Our ref: DOC21/1010877

Your ref: SSD-21854025

Environmental Impact Statement – New Wee Waa High School (SSD-21854025)

New Wee Waa High School – Biodiversity Development Assessment Report (version dated 5 November 2021)

01 CENTRAL COURTYARD LANDSCAPE PLAN  
LP04 Scale: 1:200

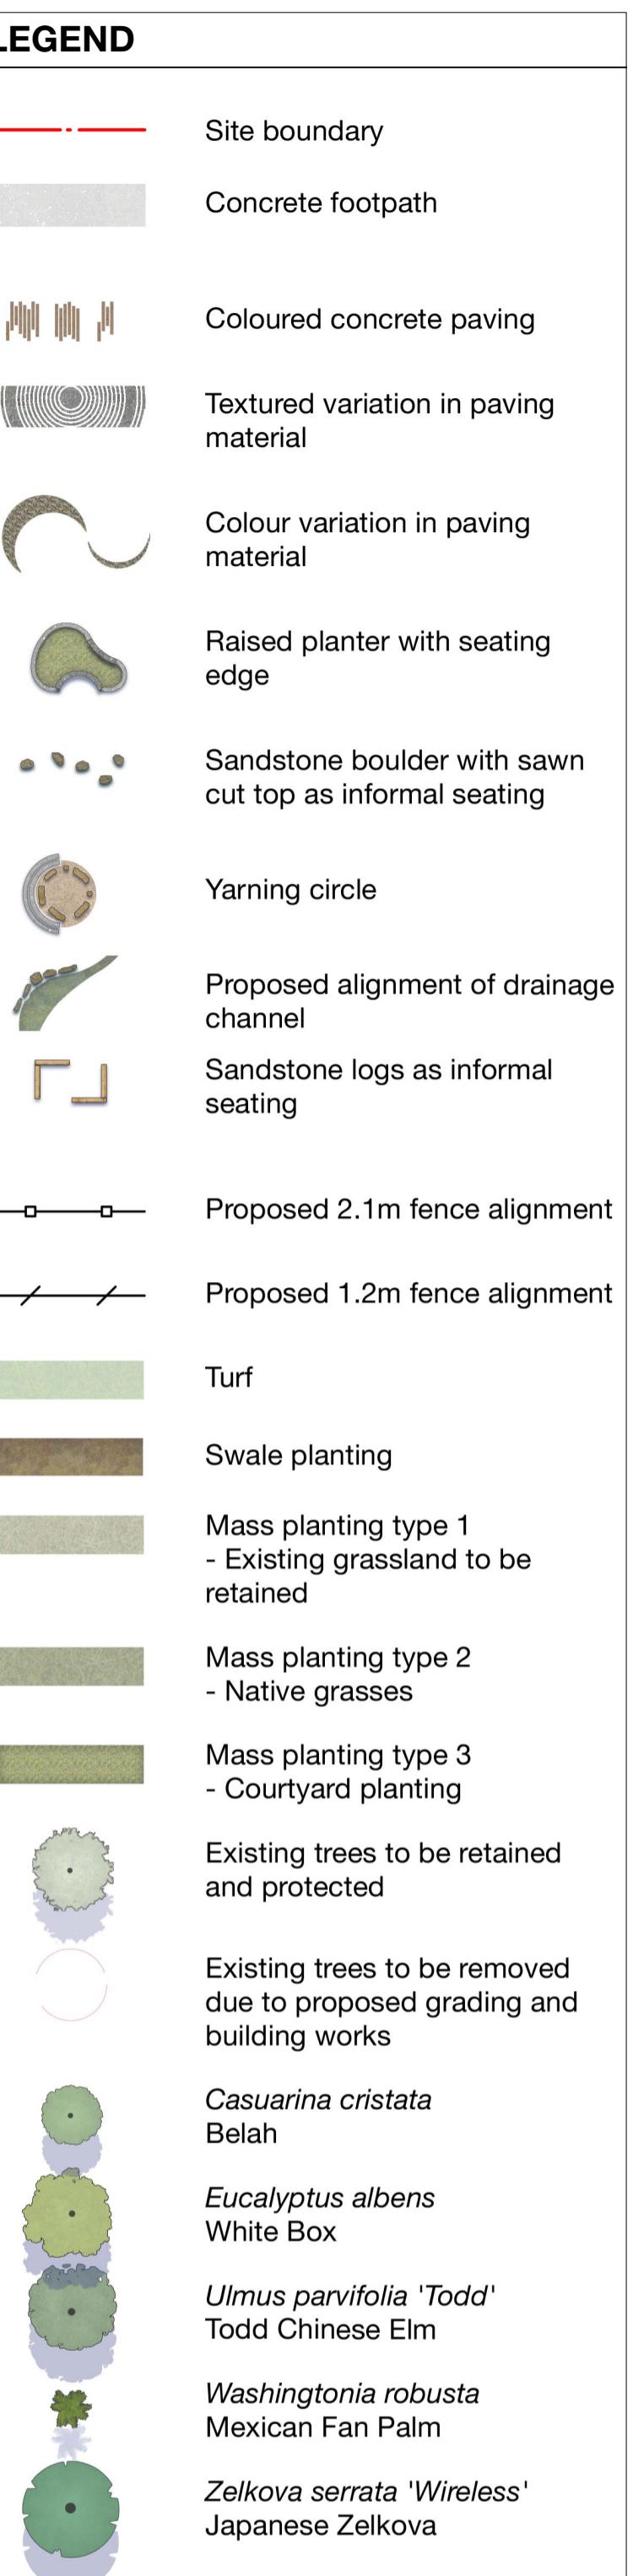
The landscape plan appears to indicate that an entrance path will bisect this management zone, which does not align with the footprint presented in the BDAR.

- 4.1 Justify the attribute values used to calculate the future vegetation integrity score for management zone 2b, including:
 - a) details of the management regime proposed. At a minimum this should include:
 - i. objectives of the managed area
 - ii. frequency and timing of slashing
 - iii. clarification of the method to be employed to reduce existing canopy cover to 15% (tree removal or tree lopping)
 - iv. area of clearing associated with proposed infrastructure within the zone
 - v. intentions regarding fallen timber within the management zone
 - vi. proposed weed control targets.
 - b) Evidence-based assessment of likely response of the flora species present (and threatened flora species assumed present) to the proposed management regime.
